## URBAN DESIGN BRIEF

**601 LAURIER AVENUE W**

20 JUNE 2024

1 WEST ELEVATION - ANDREW FLECK HOUSE  
A202 SCALE: 1:100

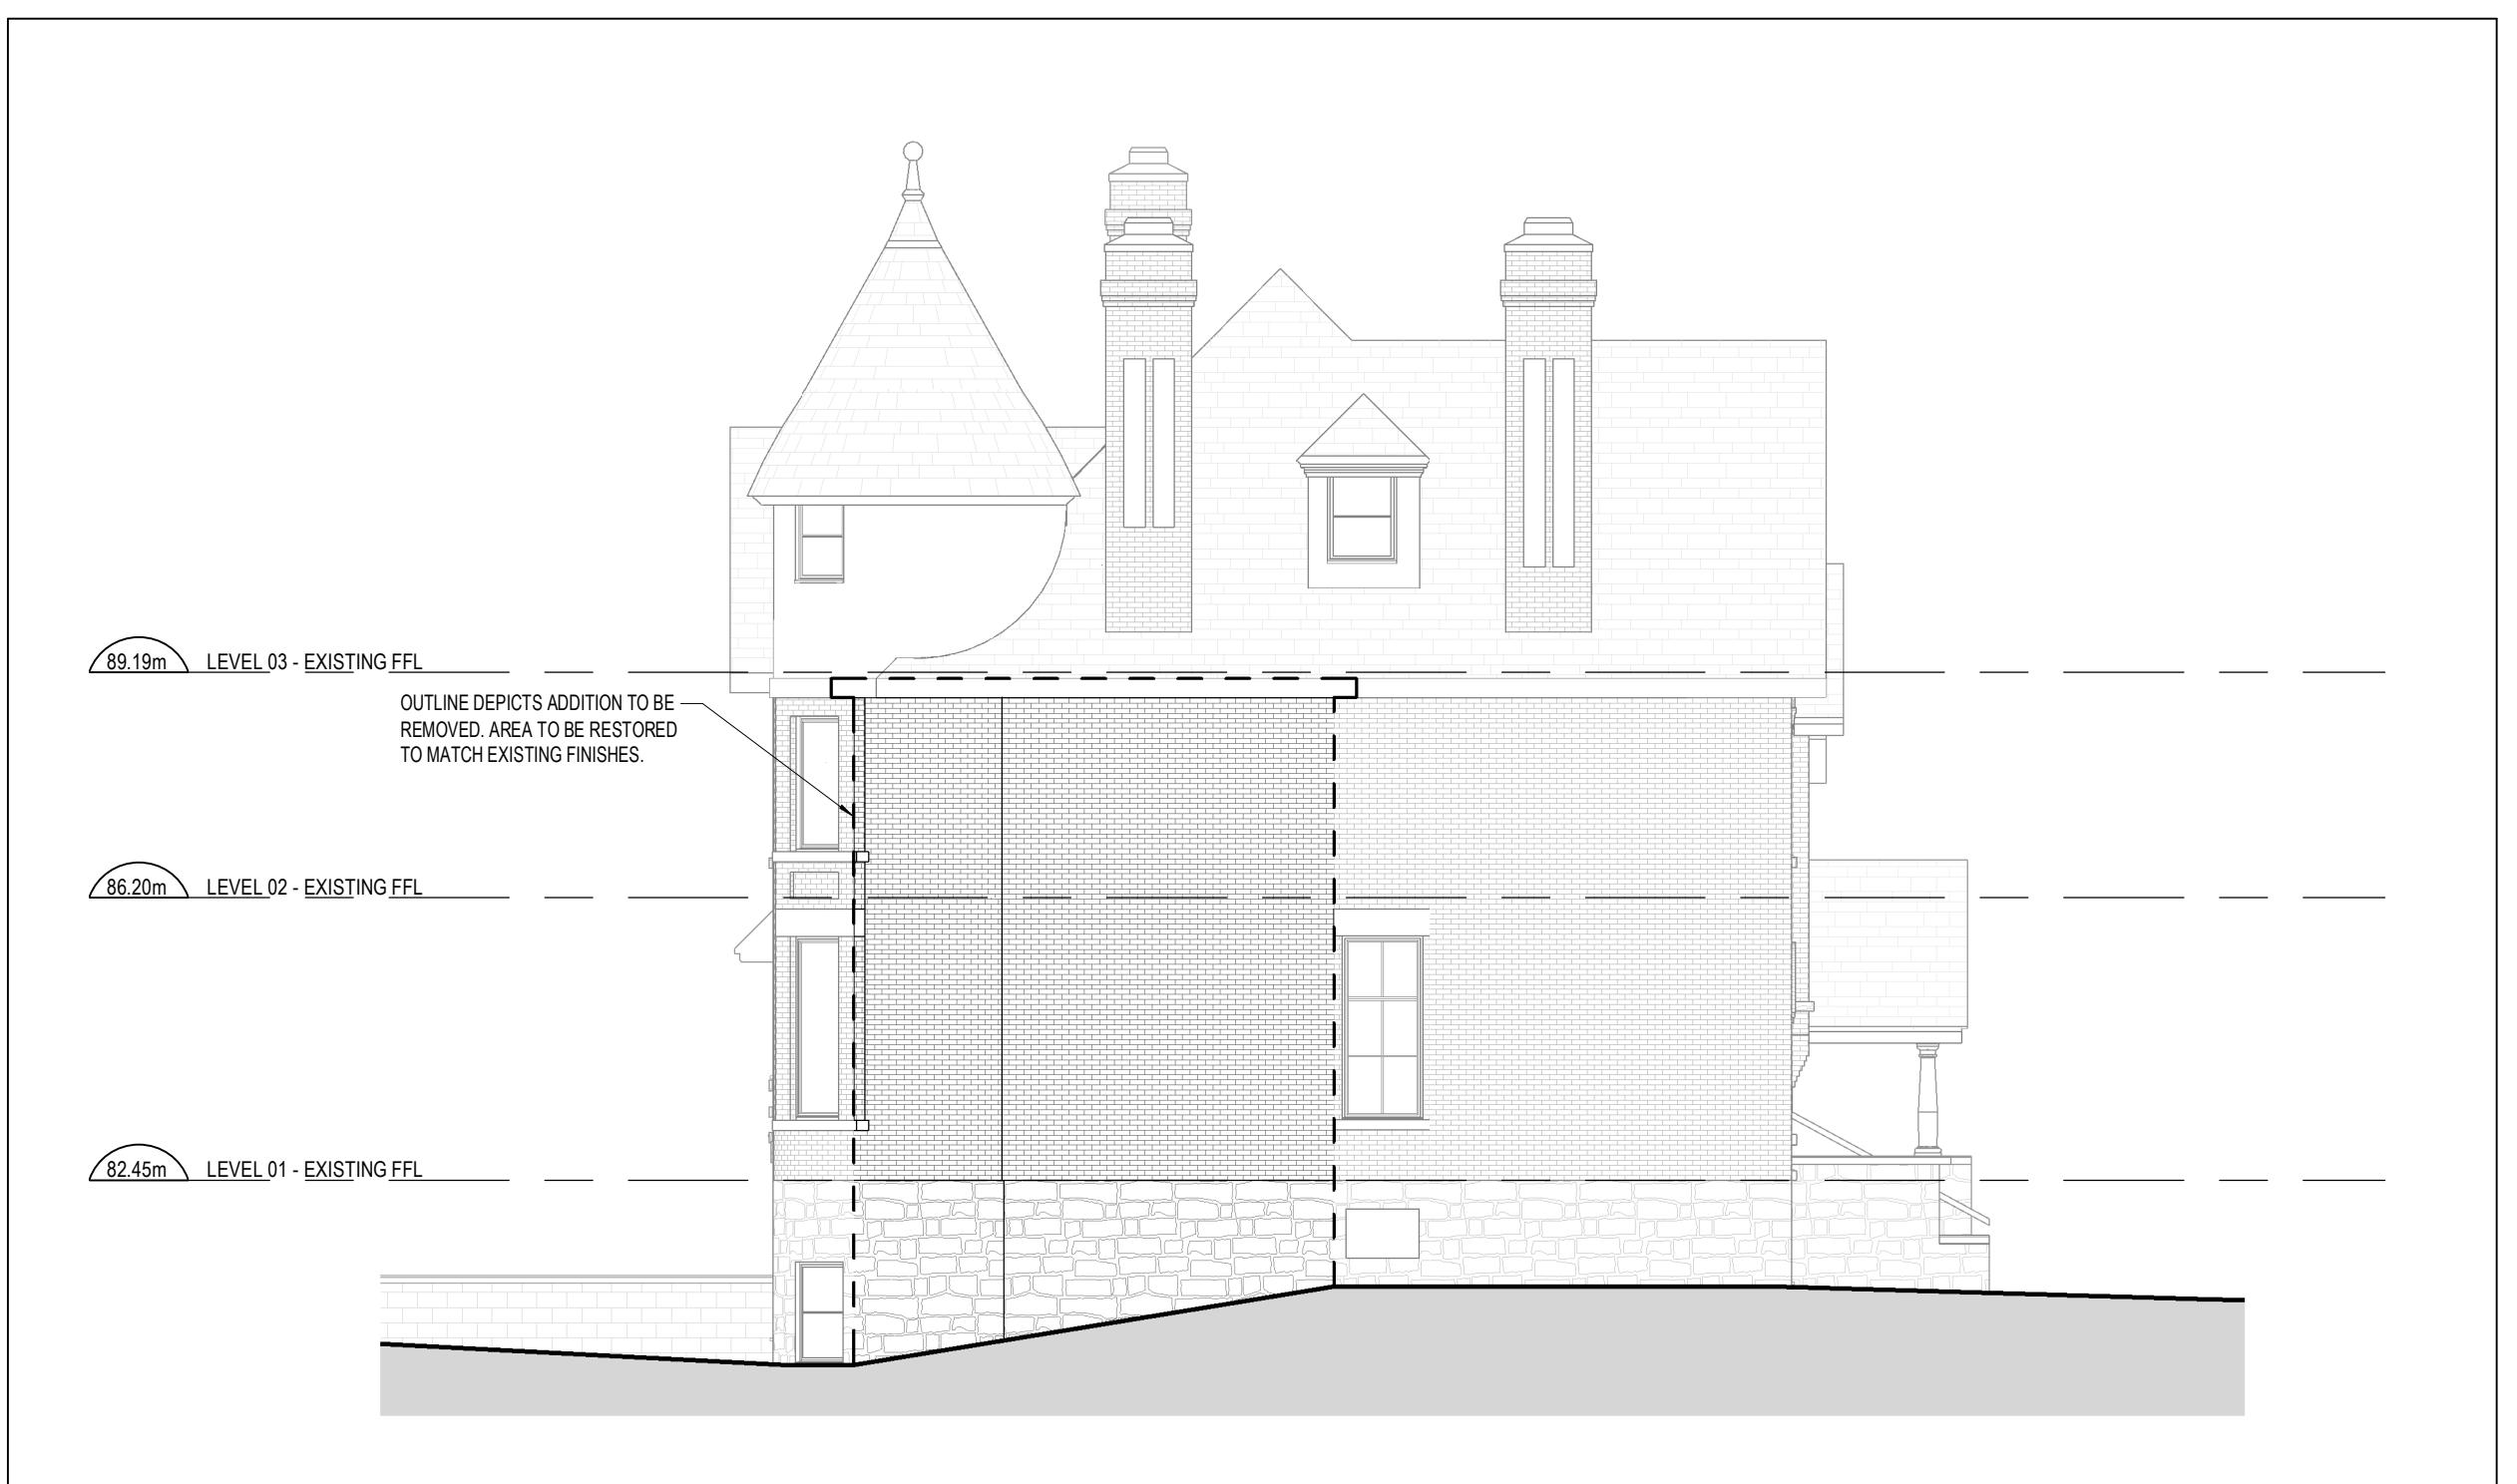
The podium may be high for the neighbourhood context and especially the relationship to the heritage house on the property. We recommend providing additional design/massing details so we may better understand the approach being taken.

We have increased the separation from the heritage house to 4.5m from 3m and introduced a stepback and material change above level 4 to better integrate the podium with the neighborhood context. These adjustments help to mitigate the podium height and ensure a more harmonious relationship with the heritage house.

601 LAURIER AVENUE PROJECT MASSING / EXISTING AND PROPOSED CONTEXT

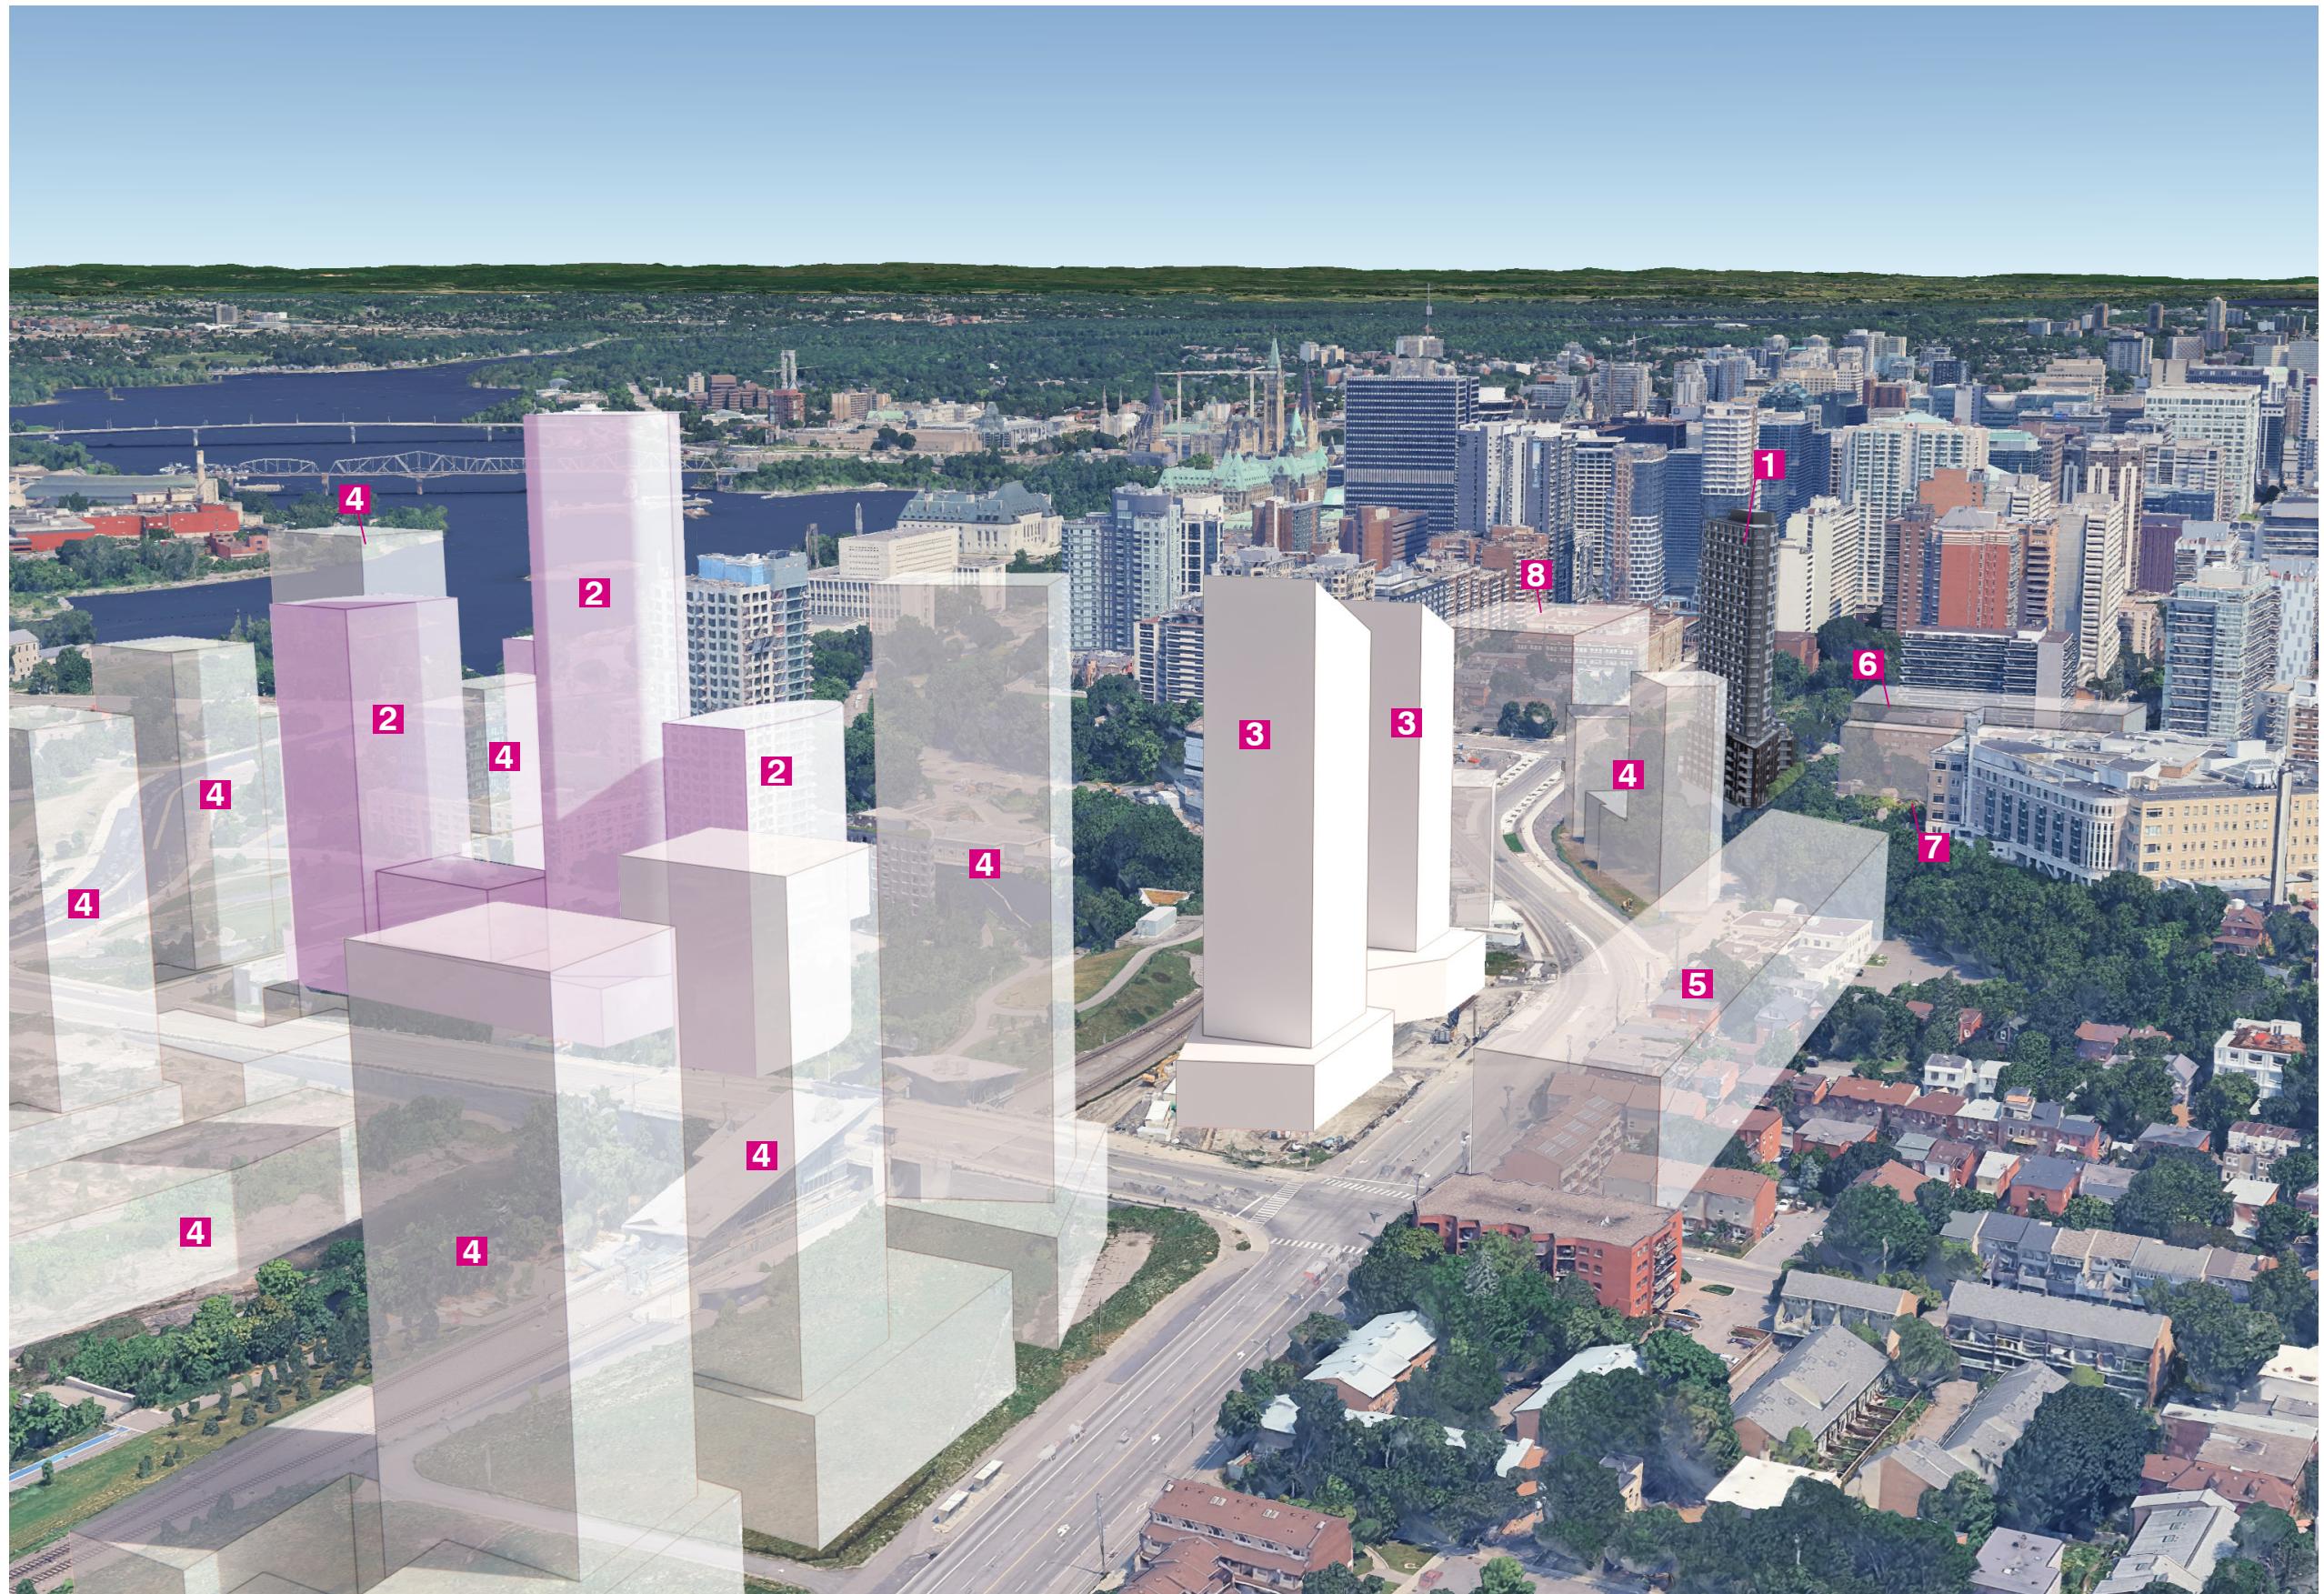
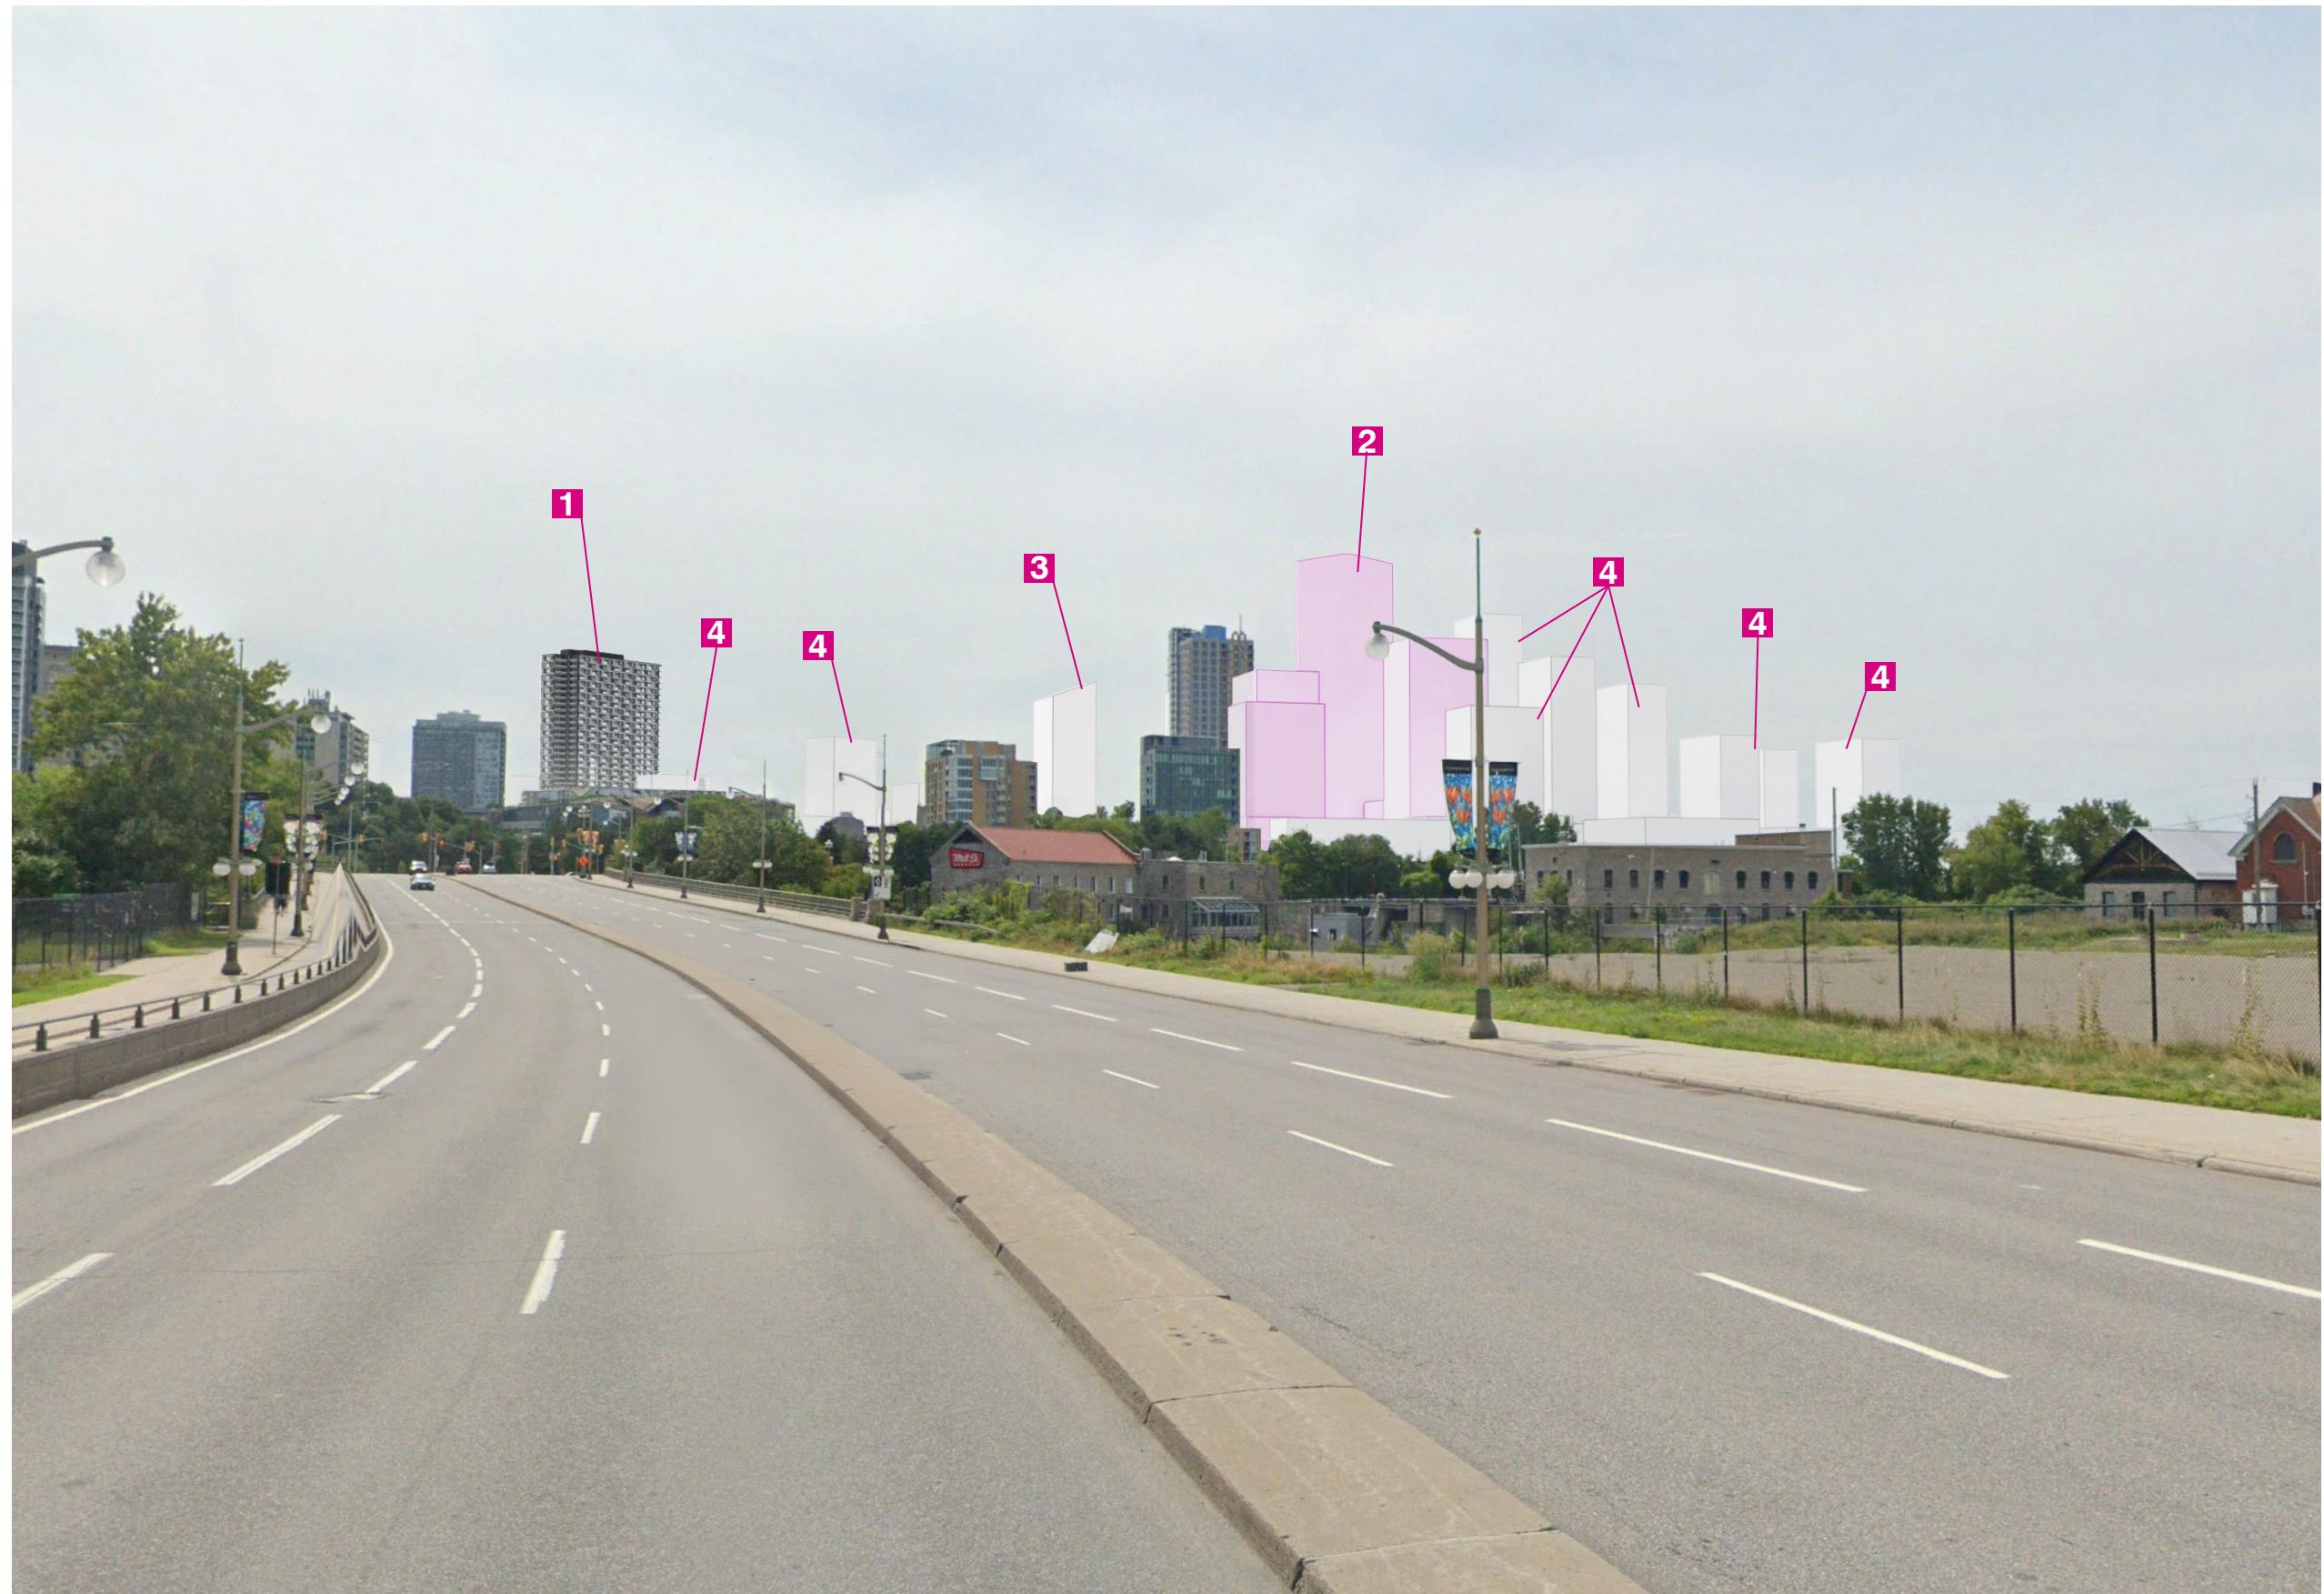
We recommend providing massing of the project and its context to better understand the future relationship to the existing context of the surrounding properties and their planned context. Be sure to include the properties down the escarpment and along Cambridge, Laurier, Bronson and where Slater has been removed.

We have provided material illustrating the massing of the project and its context, showing the relationships with the escarpment and surrounding properties. This includes properties down the escarpment and along Cambridge, Laurier, Bronson, and the area where Slater has been removed. These visuals help to better understand the future relationship to the existing and planned context of the surrounding area.
